**KIRKLEES COUNCIL
TOWN AND COUNTRY PLANNING ACT 1990
HIGHWAYS DEVELOPMENT MANAGEMENT**

PLANNING REF 2017/62/91047/E0/ET
CATEGORY Minor

PROPOSAL	PART DEMOLITION OF FIRE STATION AND ERECTION OF 4 NO WAREHOUSE UNITS AND 4 NO APARTMENTS	HDC Ref. No.	K14-8NW/3
		Highway Officer	Mark Berry
		O. S. Ref.	233 207
		Date Received	23/05/2017
		Target Date	13/06/2017
		Date Returned	16/06/2017
		Decision	
		Route No.	A644
		Road Name	HUDDERSFIELD ROAD
		Adopted	Yes
		Footpath	No
		Highway scheme	Yes
		TRO'S	
		Checked by / date	Sam Lewis 23/05/2017

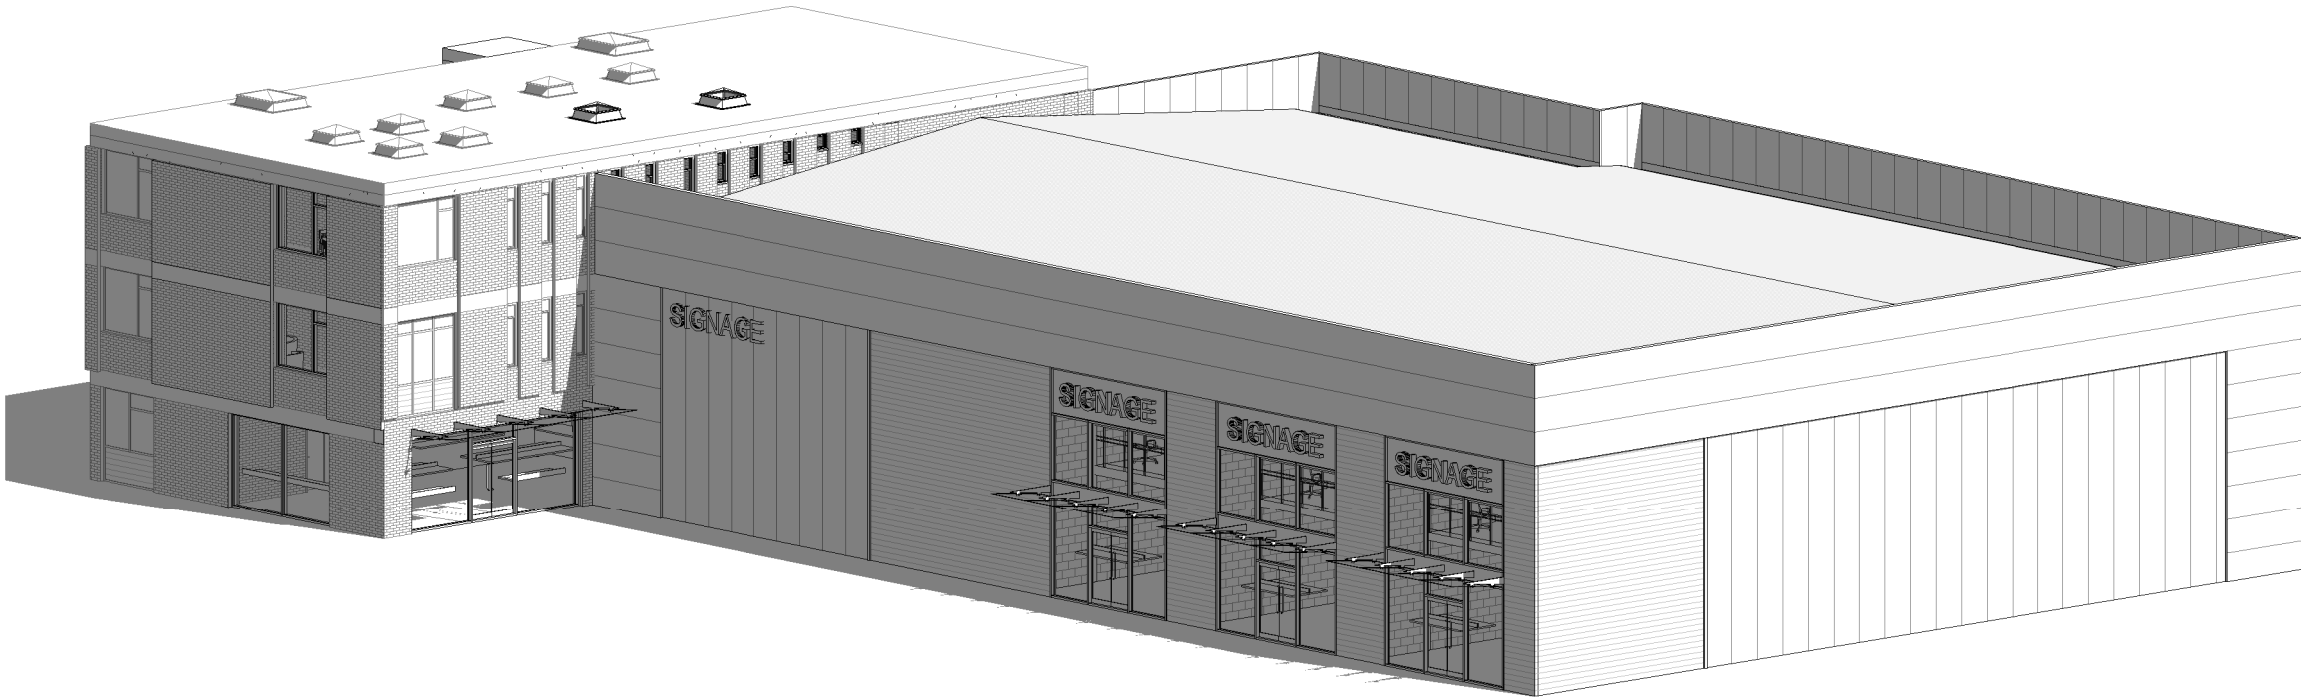
1, No internal turning is provided for larger HGVs and delivery vehicles including 16.5 metre articulated vehicles will therefore need to drive through the site and either use Scouthill Road and Ravenswharf Road to the south west or Broad Street to the north east to access the A644 Huddersfield Road.

Broad Street, Scouthill Road and Ravenswharf Road are not consider suitable to meet the operational requirements of the proposed development. Highways view is that HGV internal turning should be provided with a single point of access for all vehicles onto Huddersfield Road.

2, The width of the unnamed street to the north eastern boundary of the site is only approximately 4.5m which will result in difficult turning and manoeuvre. Ideally these parking spaces should be widened to improve access.

3, A scheme detailing measures to manage parking on Huddersfield Road along the development frontage together with appropriate Safety Audits was required by the previous outline permission to prevent parking and ensure sight lines onto Huddersfield Road are maintained. This is considered necessary for this proposal given that a similar point of access onto Huddersfield Road is proposed. This should be noted on the plans.

4, Sightlines from the proposed access should be shown on the plans

5, The redundant footway crossings onto Huddersfield Road and Broad Street should be shown to be removed and the footway reinstated
